POST EPC MEMORANDUM

RE: PR- PR-2018-001482, SI-2023-01925–Site Plan-EPC _ Riverside Mobile Home Park

The agent (Tierra West) for Riverside West, LLC., has worked with Staff to fulfill post EPC requirements to meet Conditions of Approval, 1-11 for the Riverside Mobile Home Park, Site Plan-EPC, zoned R-MC; located at 211 Ervien Ln SW, northwest of the intersection of Ervien Ln and Coors Blvd. See EPC Notice of Decision (NOD) dated January 18, 2024.

**RIVERSIDE MOBILE HOME PARK**  
 2911 ERVIEN LN SW  
 ALBUQUERQUE, NM 87121

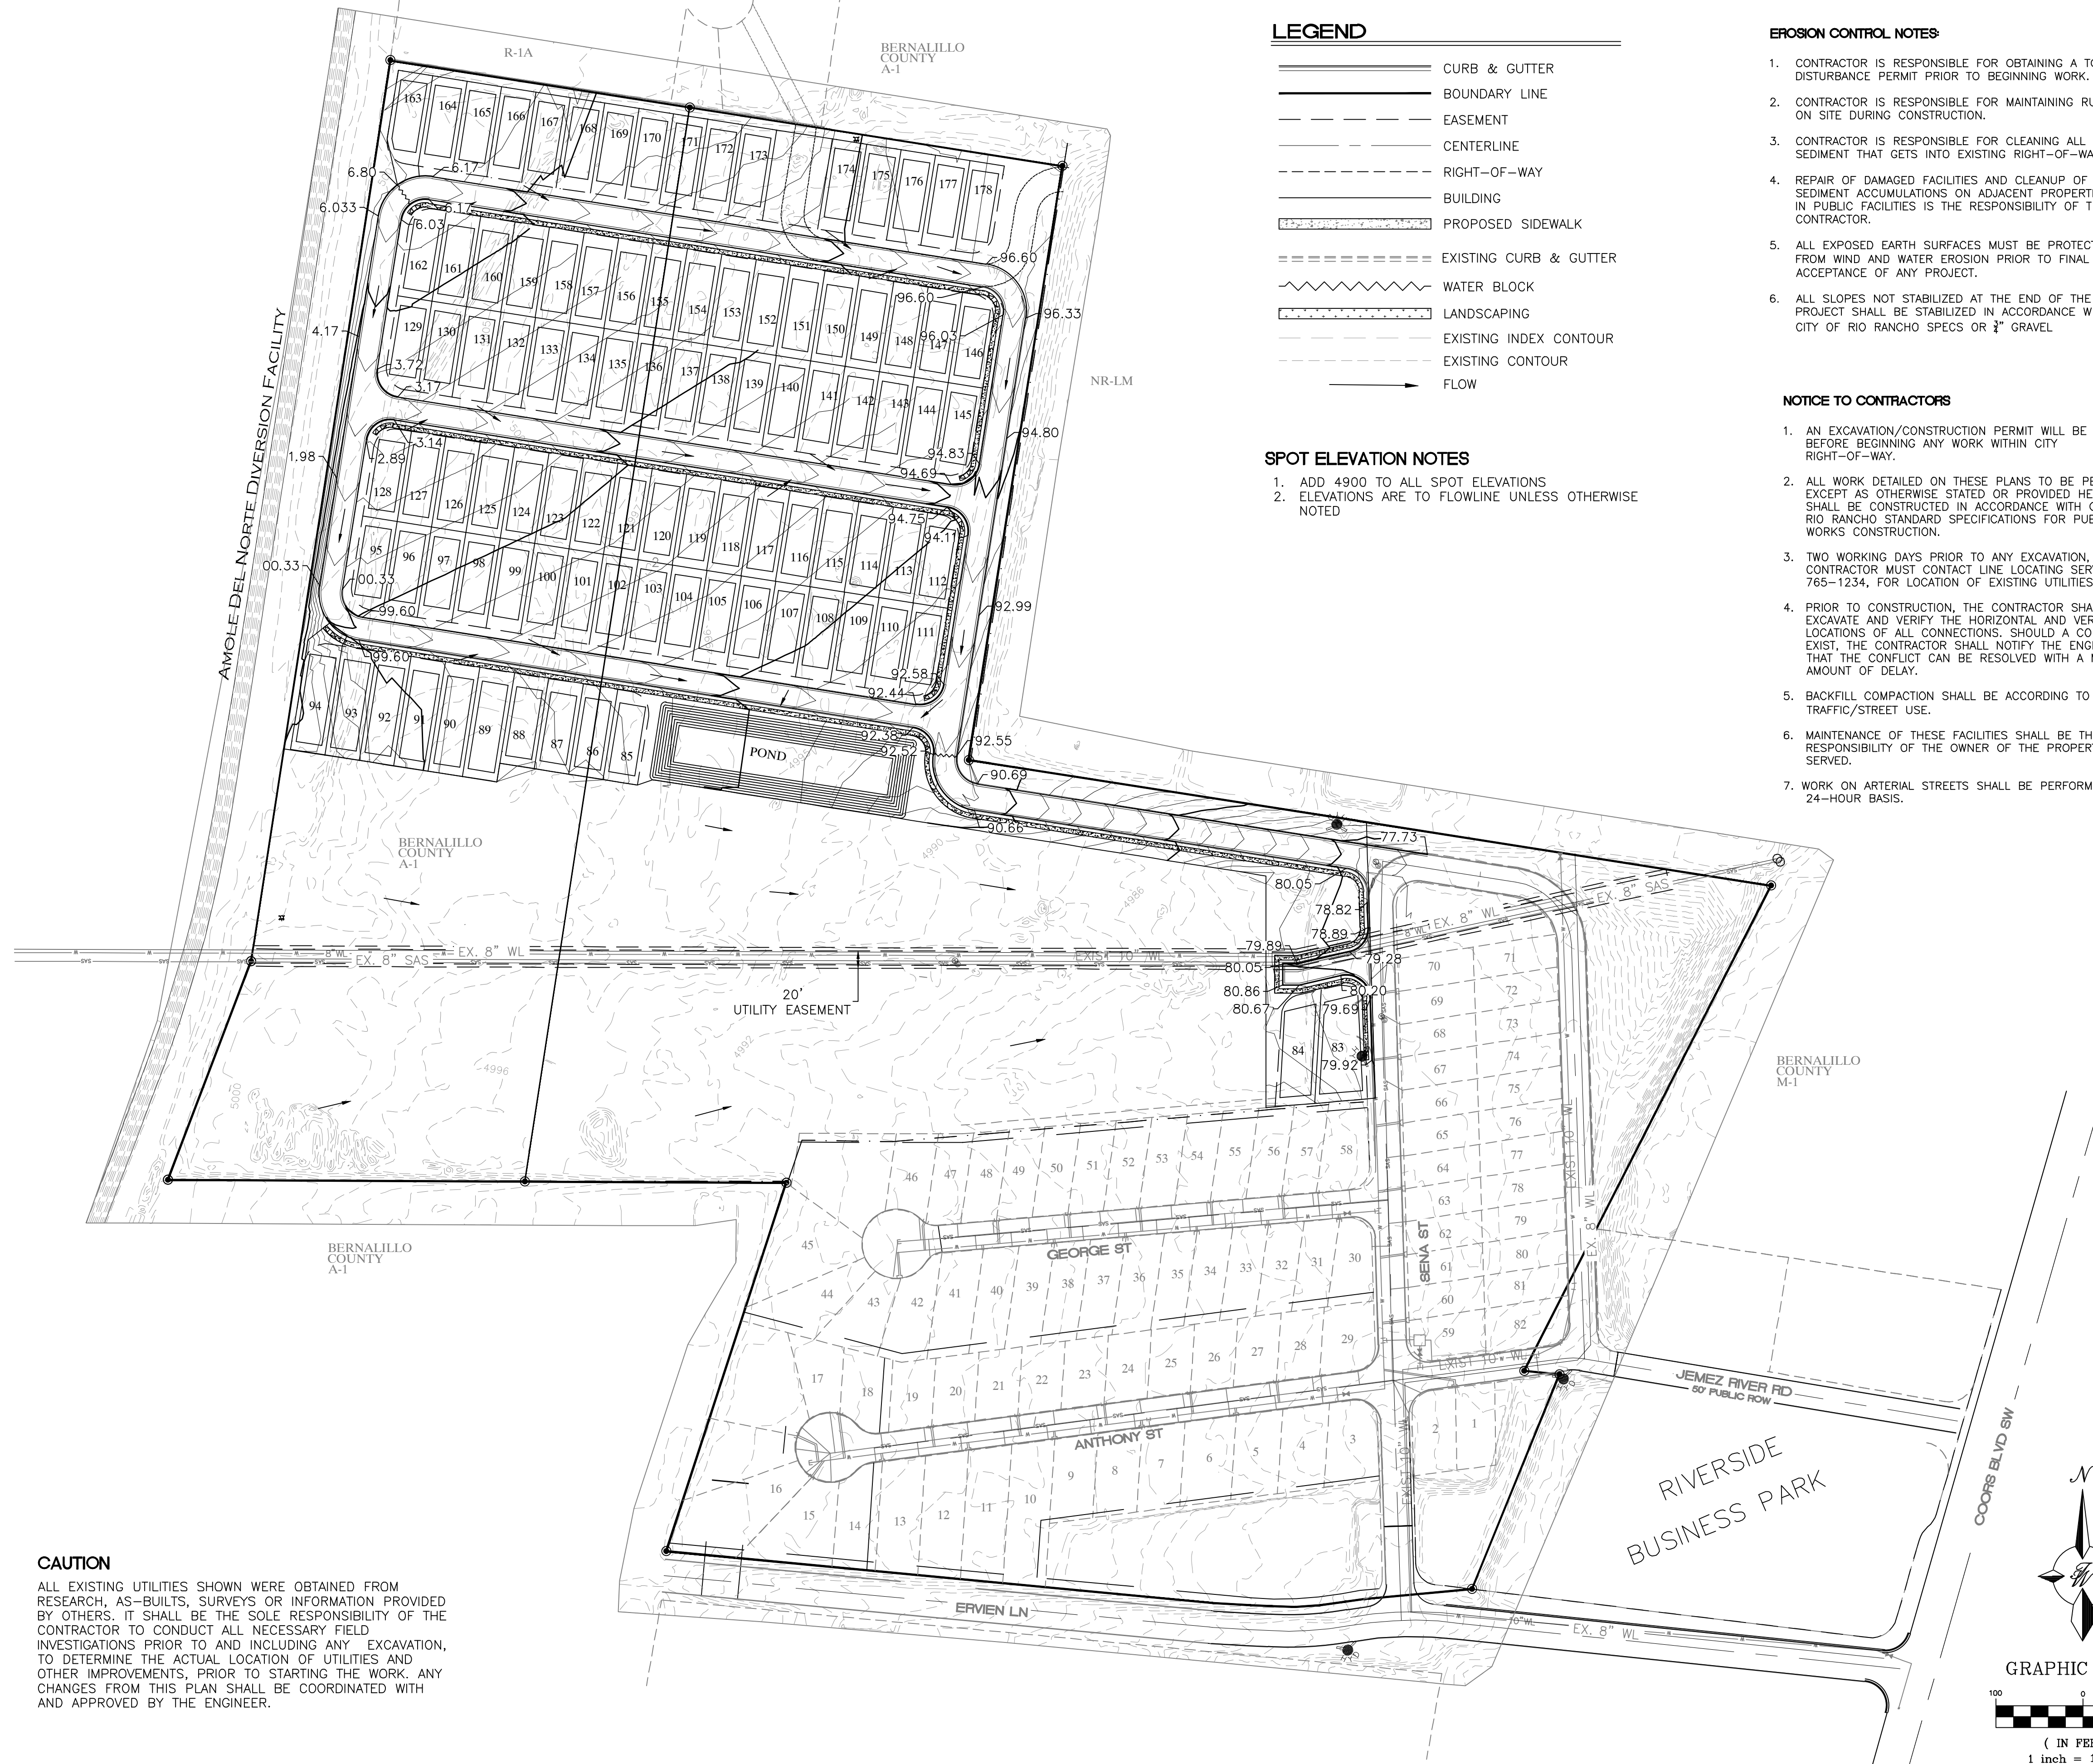
Condition 3b has been partially met. The site plan has not specified LANDFILL GAS BUFFER AREAS on the drawing or in the legend in parenthesis next the LANDFILL LIMIT.

<b>SOUTH VALLEY MHP</b> ALBUQUERQUE, NM	DRAWN BY JL
	<b>CONCEPTUAL GRADING</b> AND DRAINAGE PLAN	DATE 4/27/2023
ASSAD A. RIZVI P.E. #27632	TIERRA WEST, LLC 5571 MIDWAY PARK PL NE ALBUQUERQUE, NEW MEXICO 87109 (505) 858-3100 www.tierrawestllc.com	SHEET # <b>C2.0</b>
		JOB # 2022056

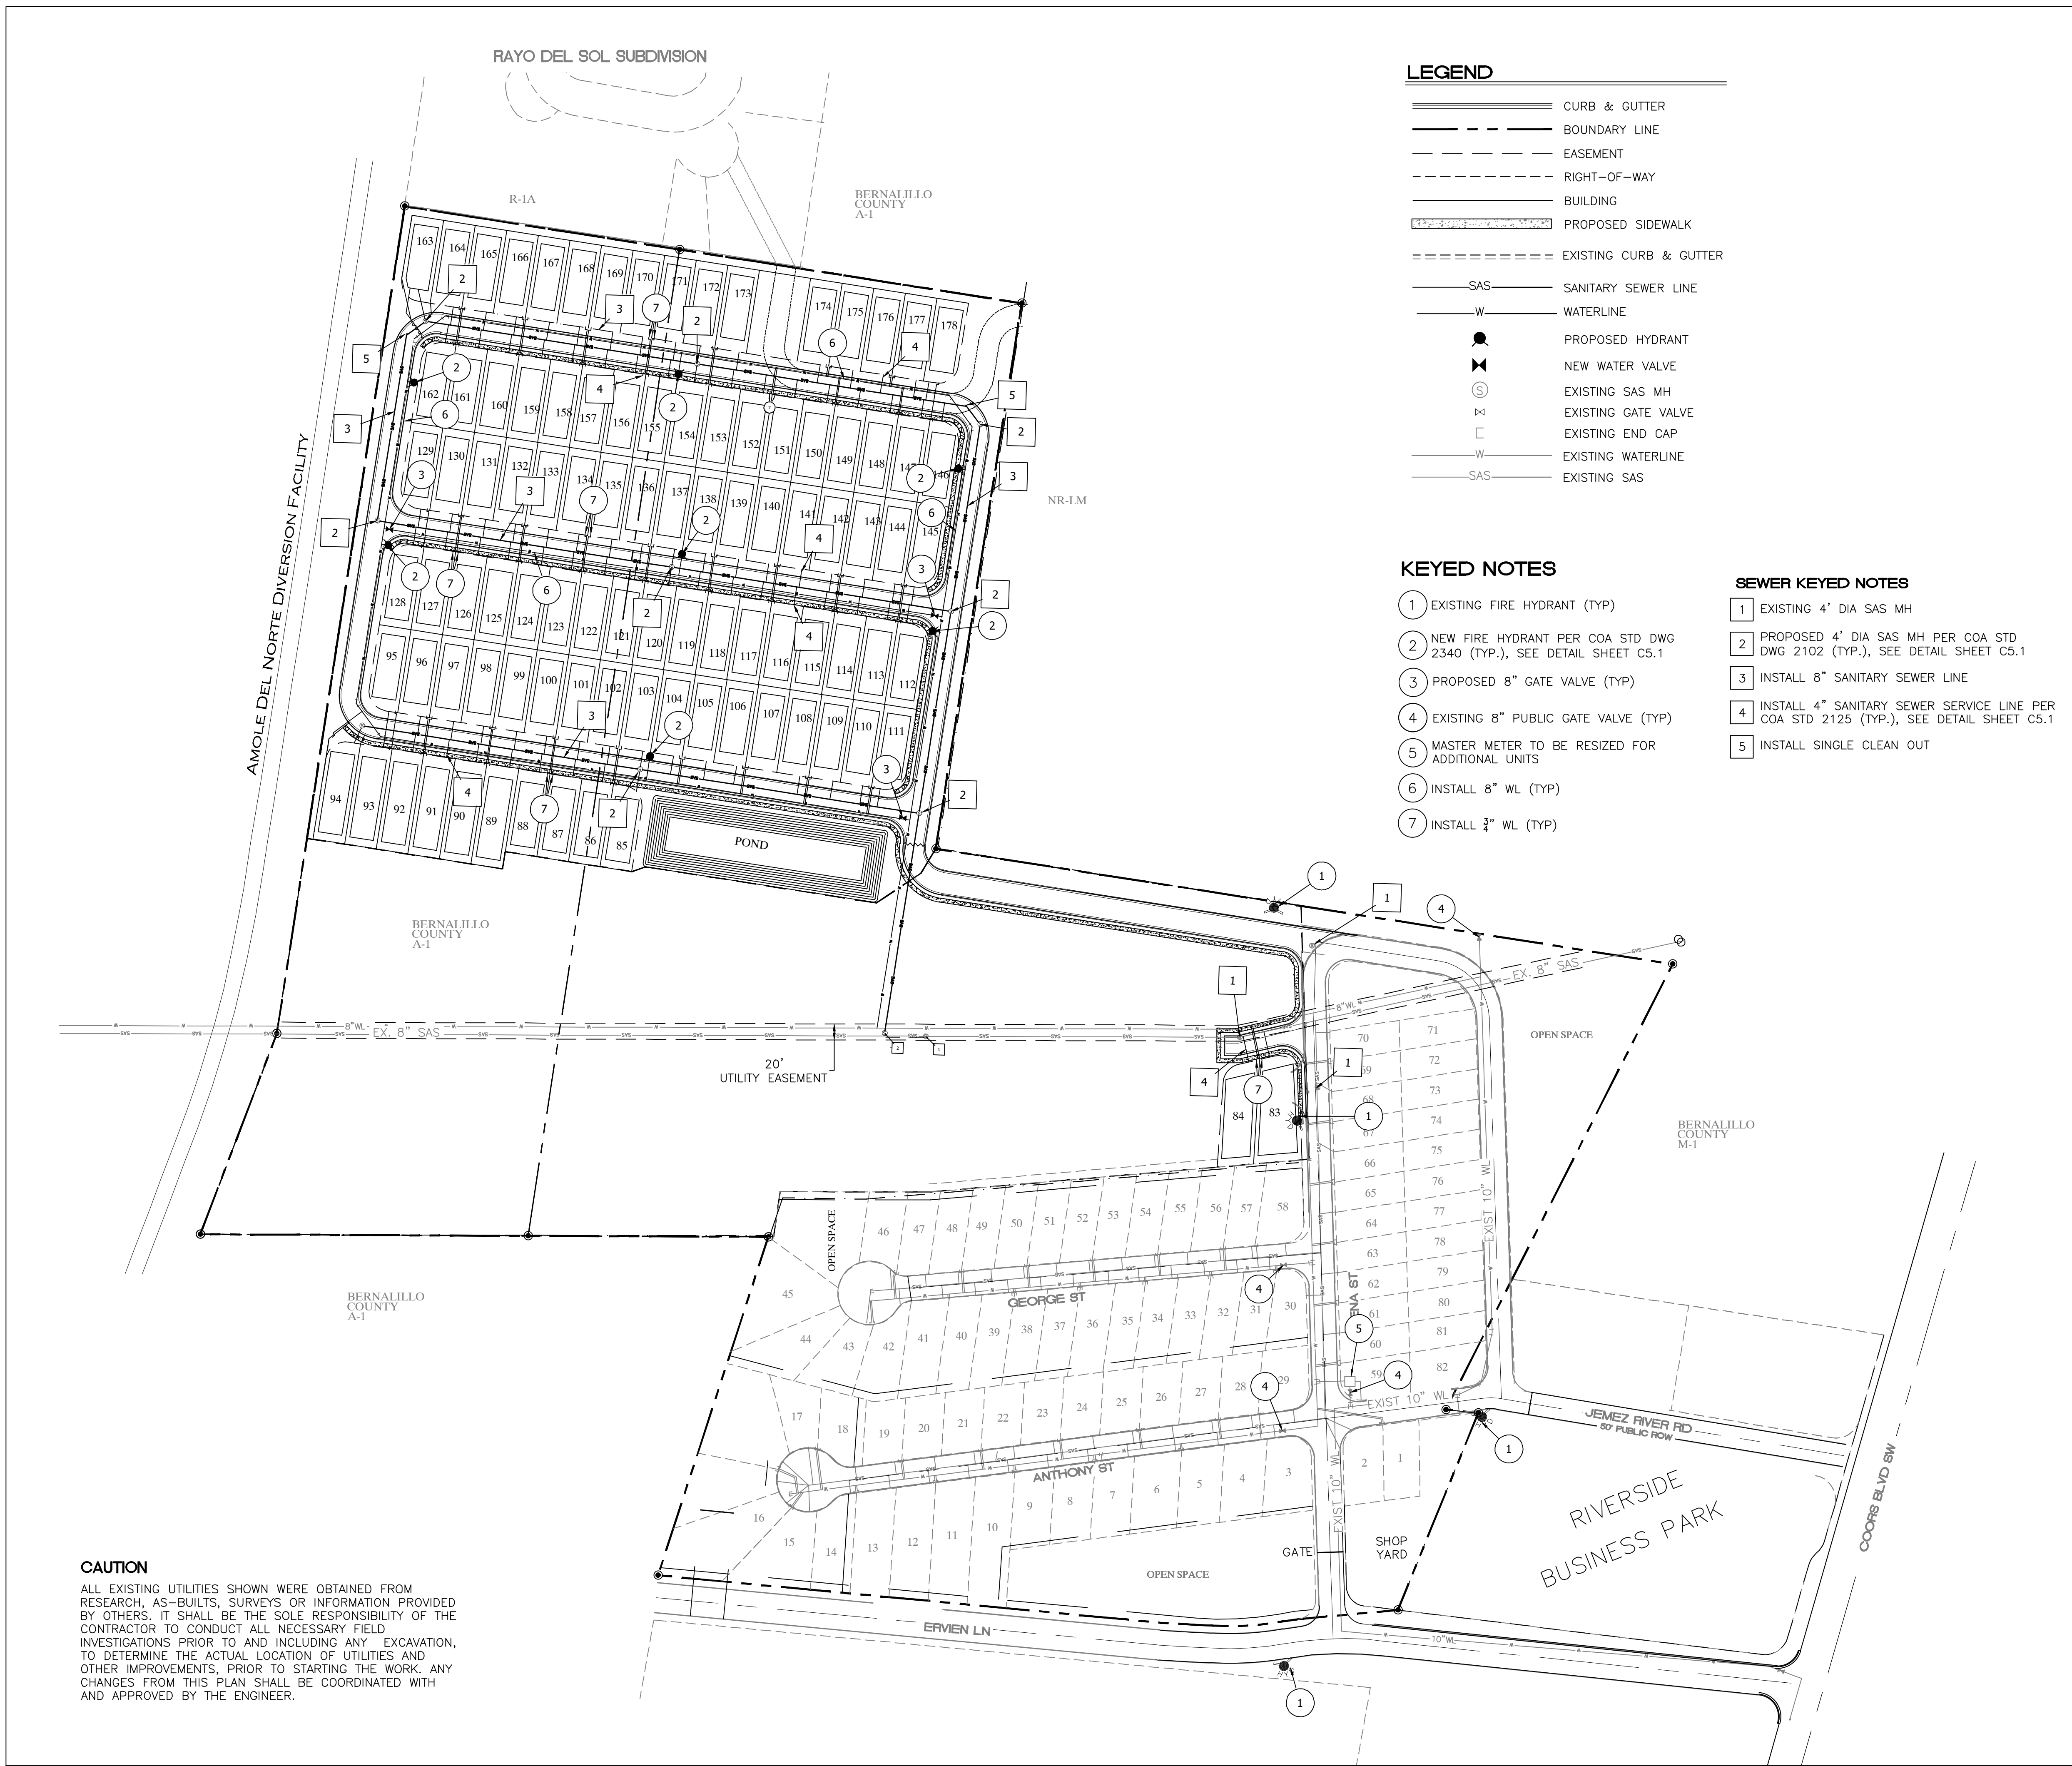
5. Condition 5 has been met. Conceptual Grading and Drainage Plan has updated text to use "City of Albuquerque" instead of Rio Rancho.
6. Condition 6 has been partially met and replaced with a standard 16' max light pole detail on sheet C5.0. The note, "within 100' of Residential" was not added to the max light pole detail.
